RE: Afreya's Playground, Fuquay Varina

An application for the above referenced facility was received and reviewed by this office. The following items are in need of attention:

Cindy Pierce, REHS
Environmental Health Section
Harnett County Health Department

**AFREY'S PLAYGROUND**  
 12082 NC HWY. 42, FLOUAY VARINA, NC 27526  
**PLUMBING WATER PLAN**

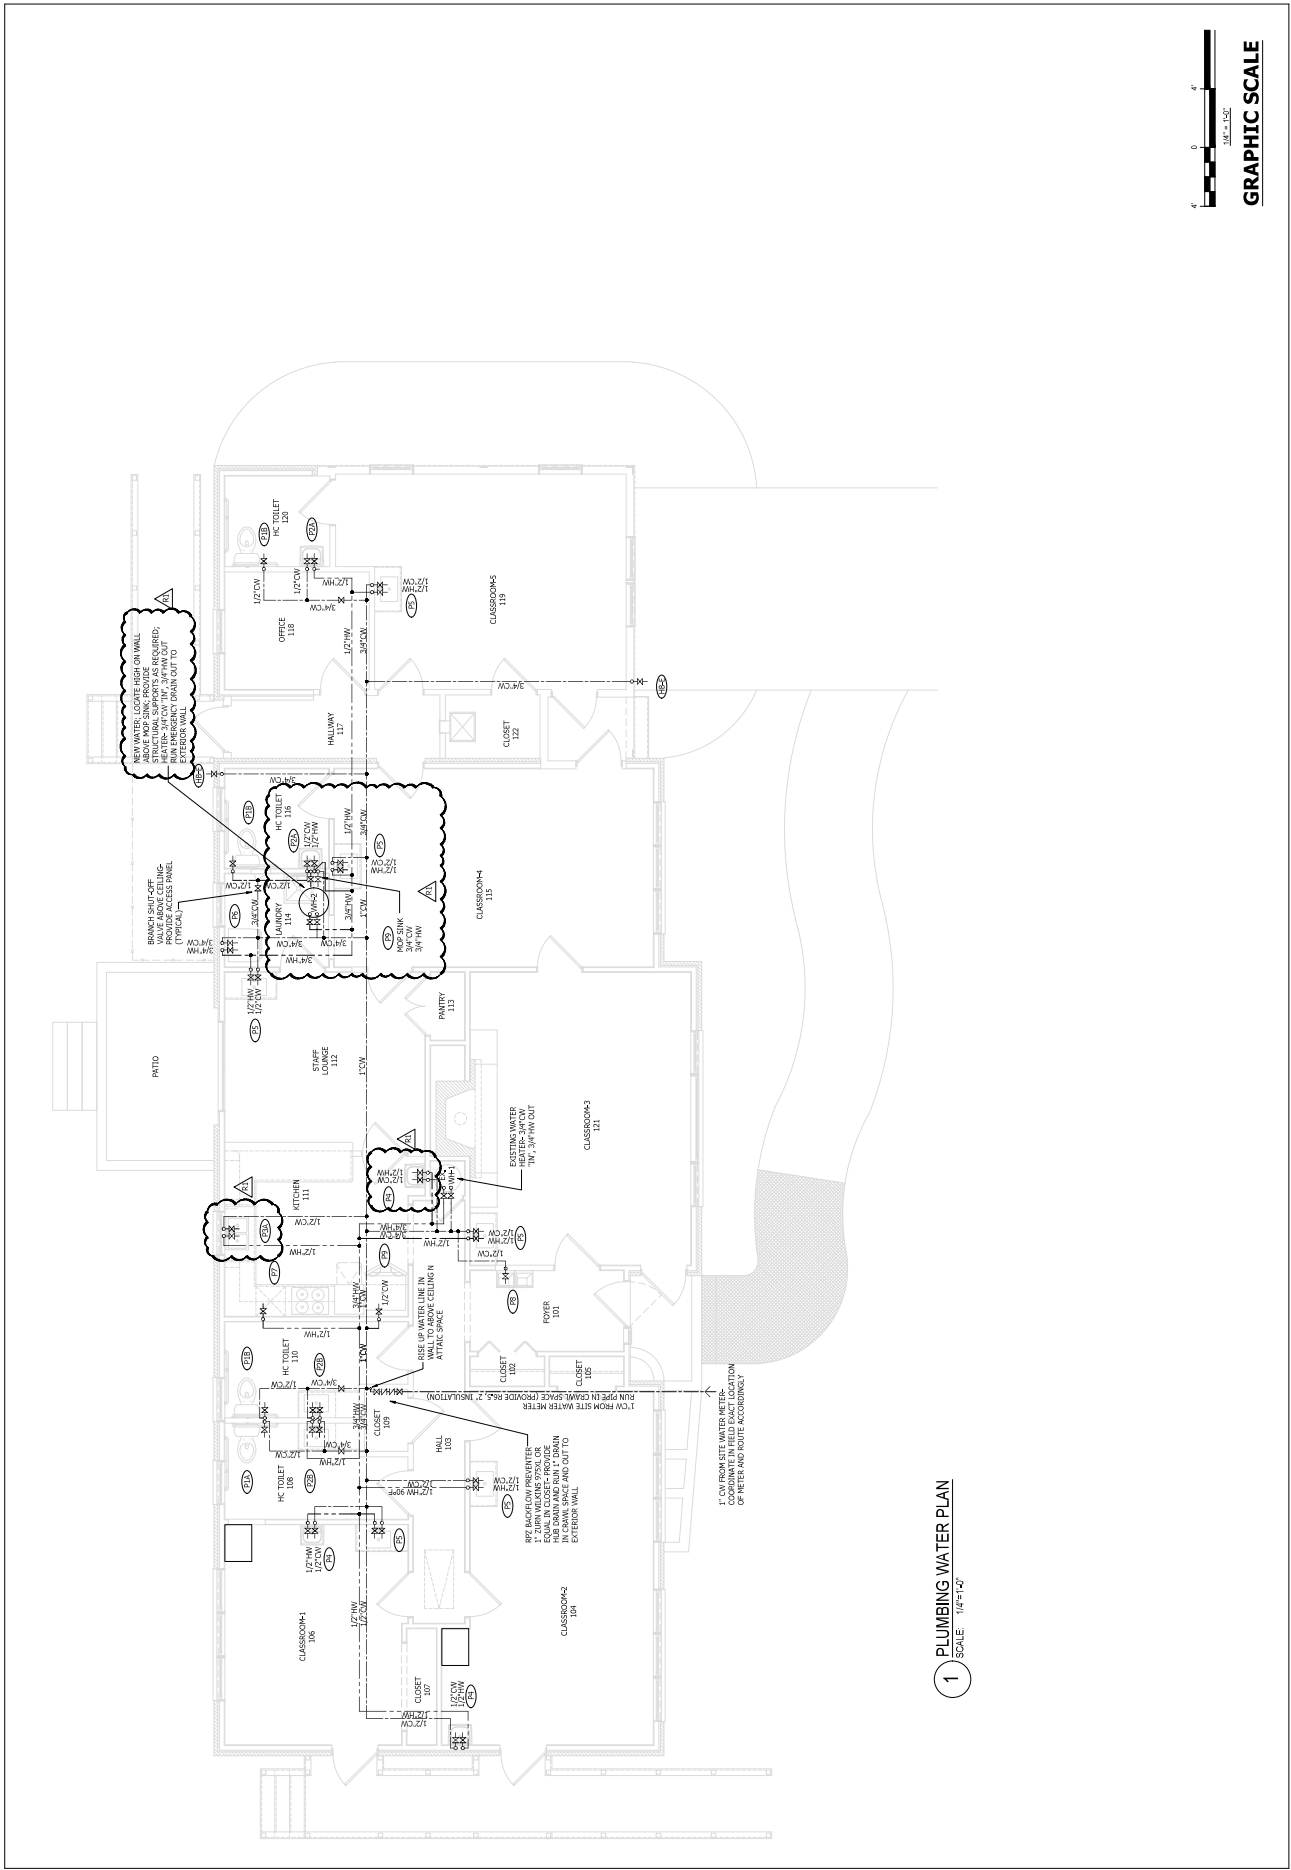
- It is understood that the kitchen equipment is the existing home domestic equipment. Please indicate if the existing sink is one or two compartments and whether the dish machine has a sanitizing cycle.
- The application states a separate handsink is provided in the kitchen however the plumbing plans appear to only show the existing kitchen sink.
- Floor plan layout is not detailed to show age groups of children in each classroom, all diaper changing areas, and location of canwash.
